The North Wales Wind Farms Connection Project

SP Manweb's Response to Late Deadline 1
and Deadline 3 Representation from Eifion
Bibby relating to Requests for Relocation
of Poles

Application Reference: EN020014

Deadline 4 Submission

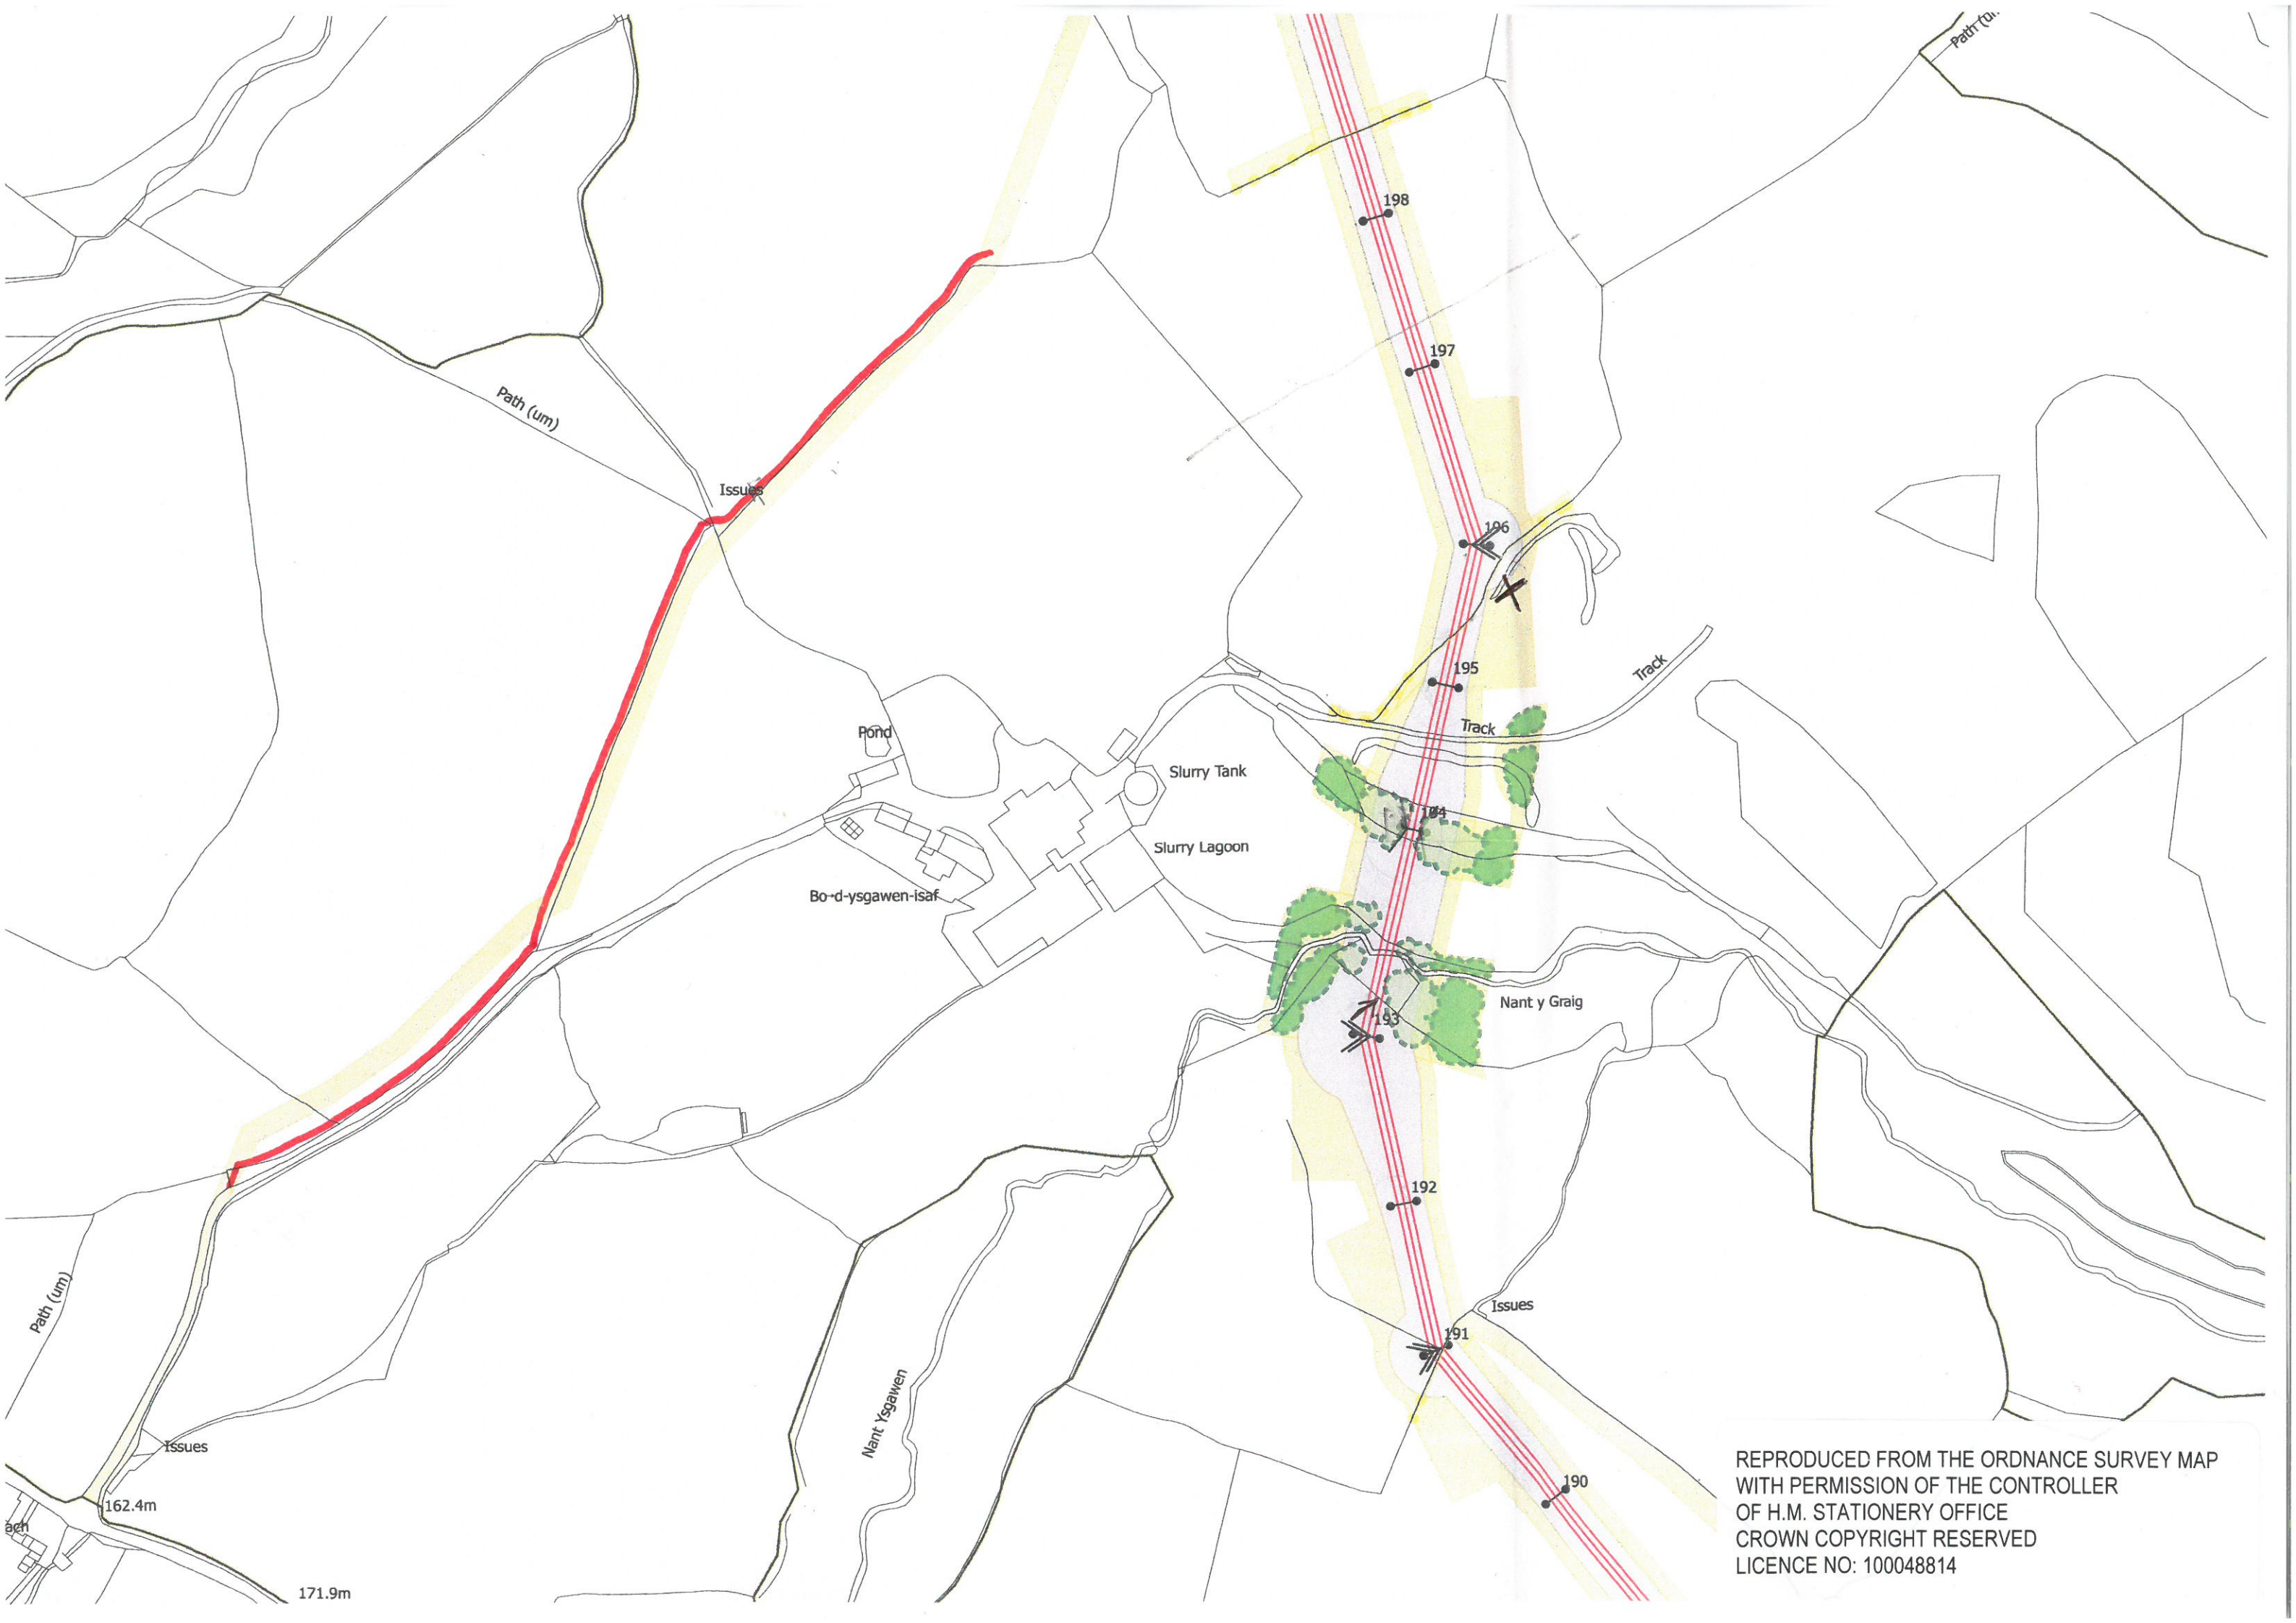
Respondent	Written Representation	SPM response
		<p>However, a meeting has been arranged with Mr Bibby to discuss this and terms of the voluntary Option and Easement agreements.</p>
<p>Eifion Bibby on behalf of Mr AEM Owen</p>	<p>Dear Sir,</p> <p>Further to our telephone conversation of earlier today, in respect of Scottish Power's Option A proposal, we confirm that our above mentioned client has asked that we request the Planning Inspectorate, please, to visit the subject affected land in his occupation as sitting tenant so as to be in a position to comprehend the request made for the following modifications to the scheme proposal.</p> <p>In order to reduce the significant impact of the proposed scheme on agricultural use of the subject silage/arable land, our client is seeking to adjust the siting of proposed Poles (stays) 193, slightly due north, closer to the hedge line, and even more significantly Poles (& stays) 196, due east, where approximately shown by 'X' on the accompanying Site Plan (with the poles and stays being as close as possible to the field boundary near the old quarry).</p> <p>...</p>	<p>These suggestions were put to SP Manweb prior to submitting Option B.</p> <p>SP Manweb has considered these suggestions but has not been able to incorporate them into the Option B design.</p> <p>Pole 193 is, in SP Manweb's opinion, in the most appropriate position. If the pole was to move to the north as suggested, this would introduce clearance infringements relating to overhead line clearances as contained within ENA Technical Specification 43-8 due to the ditch/ravine located between poles 193 and 194.</p> <p>If pole 196 was moved due east, this would increase span lengths beyond specification limitations and also the pole and stays would need to be located in a quarry. This would create ground clearance infringements due to the relatively lower ground level of the quarry. As a result, the line would be less than 6.7m above ground in places.</p> <p>SP Manweb's representative emailed Mr Bibby to advise that these suggestions could not be incorporated in to the design on the 26/08/2015.</p> <p>During the accompanied site visits by the</p>

Respondent	Written Representation	SPM response
		<p>Inspectors on the 23/09/2015 SP Manweb's representatives discussed the above directly with Mr AEM Owen.</p> <p>SP Manweb will continue to seek voluntary agreement with Mr Owen in relation to his Part 1 interest in the land and is in negotiations with Mr Bibby in this regard.</p>
Eifion Bibby on behalf of Mr AA Owen	<p>Dear Sir,</p> <p>Further to our telephone conversation of earlier today , in respect of Scottish Power's Option A proposal, we confirm that our above mentioned client has asked that we request the Planning Inspectorate, please, to visit the subject affected land in his occupation as sitting tenant so as to be in a position to comprehend the request made for the following modifications to the scheme proposal.</p> <p>In order to reduce the significant impact of the proposed scheme on agricultural use of the subject agricultural land, our client is seeking the following adjustments to the siting of the proposed apparatus -:</p> <ol style="list-style-type: none"> 1. Proposed Poles 182, due north to the hedge (in the direction of Poles 183). 2. Proposed Poles 184, to the next boundary line 	<p>All suggestions included in this representation were put to SP Manweb prior to submitting Option B.</p> <p>A response to each of the numbered points are set out below:</p> <ol style="list-style-type: none"> 1. It has been possible to reposition Pole 182 north in the direction of pole 183 on to the field boundary. This change forms part of Option B. 2. Pole 184 can move north to the boundary. However, SP Manweb has not made this change in Option B as our survey data and aerial photography suggests that the new pole position suggested by Mr AA Owen would be located on an existing gateway. SP Manweb considers that placing the pole in the gateway would not be of benefit to Mr Owen and therefore SP Manweb is seeking further clarification from him or his agent in this regard. In any event, SP Manweb would be
